Norwich to Tilbury National Grid: AENC-ARC-ENV-REP-0176

Summary: RR [REDACTED]

The GAAC, is an IP, on behalf of General Aviation (GA) Aerodromes adversely impacted by the NG scheme. It does not oppose the principle, but proposed route alignment adversely affects GA Aerodromes.

This addresses ES Chapter 15 and Volume 6 Appendix 15.2

The relative locations of Tibenham and Priory Farm Airfields
The proposed route alignment and the Tibenham safeguarding zone

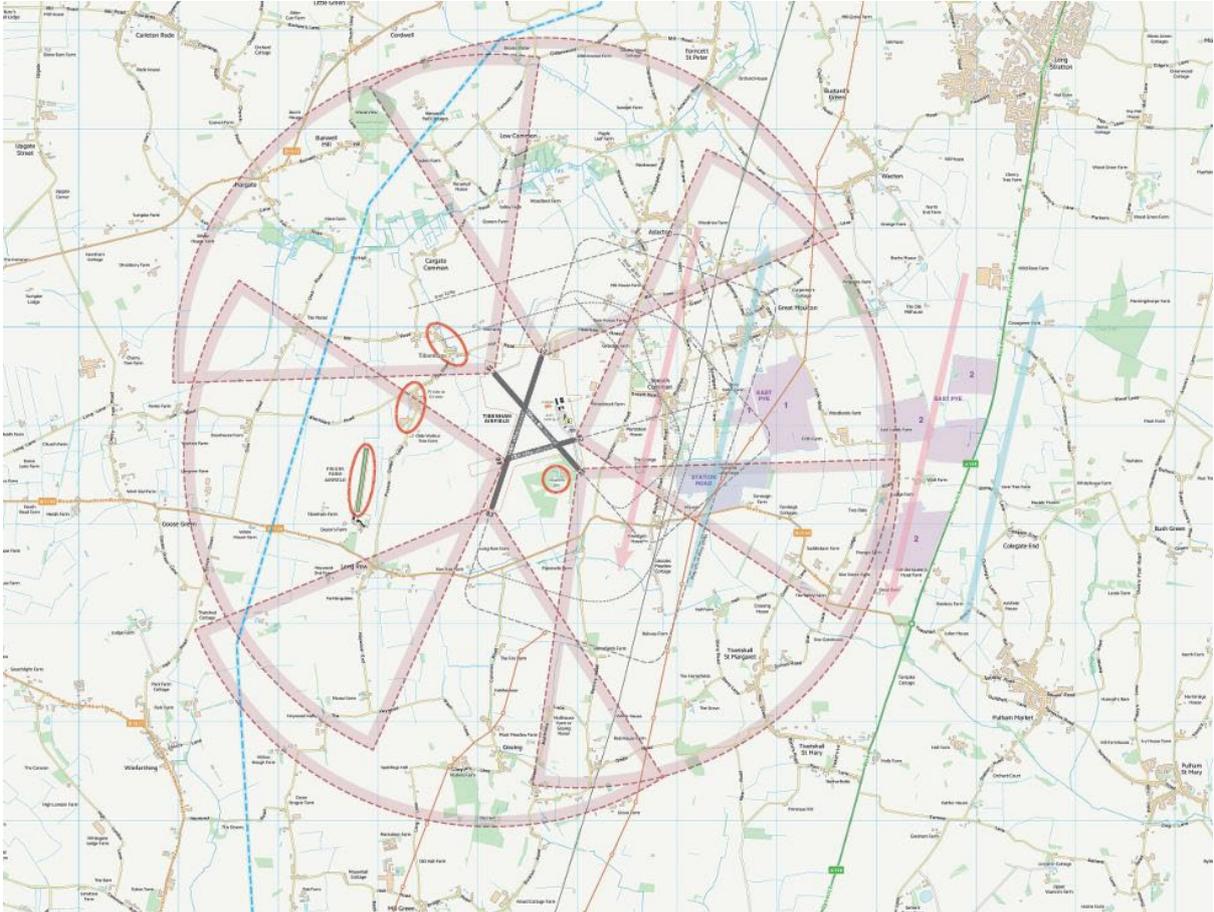
- 5.5 The specific circumstances at Tibenham Aerodrome underline the failure adequately to take account of the provisions of CAP 793. Paragraph 15.2.18 acknowledges the CAP793 requirement to have no obstacle of 150 ft within 2000 m of a runway mid-point (a climb gradient of 2.286%). The proposed pylons are 2300m from the centre of Tibenham’s runway 26 but are a continuous obstacle of at least 180ft (a climb gradient of 2.385% which is 4% greater than that implied by CAP793).

Figure 4a: PRIORITY FARM aerodrome’s larger circuit shown in green, the smaller in turquoise. Tracks for departing aircraft in dark blue from each runway end. Proposed power line infrastructure in red; existing in light blue. All circuit/departure illustrations are approximate.

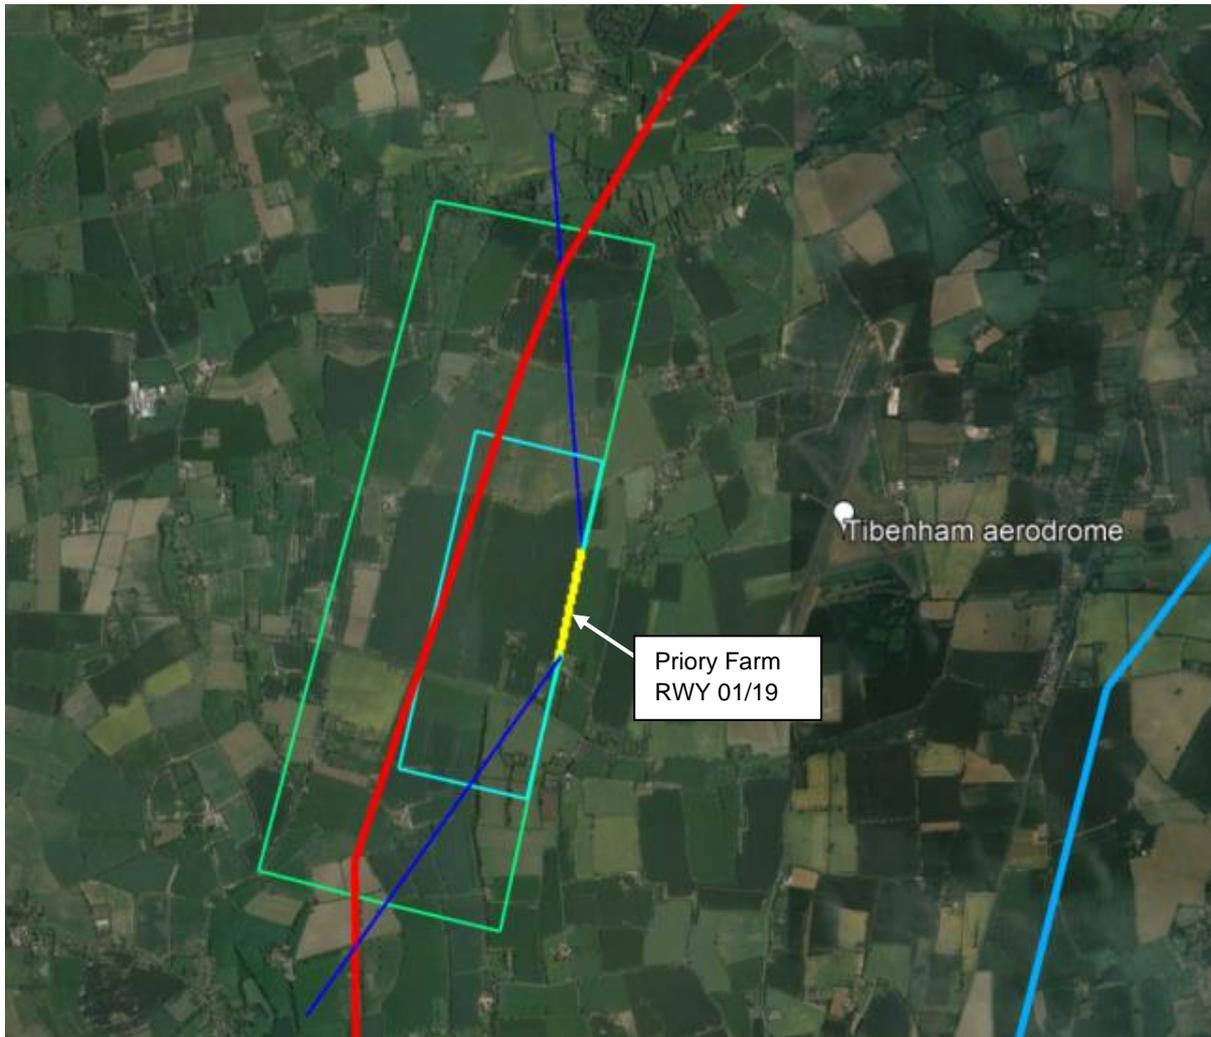
3. It concludes only Chase Farm would be subject significant adverse effects – '*as closure is anticipated*'. However, the route could have been modified. This is post-hoc justification for flawed route definition. It also suggests 'temporary' closure of Raydon Wings would take place (duration not identified). It admits it has no detailed information about the operations but concludes impact is, '*temporary, short-term, minor adverse and not significant.*'
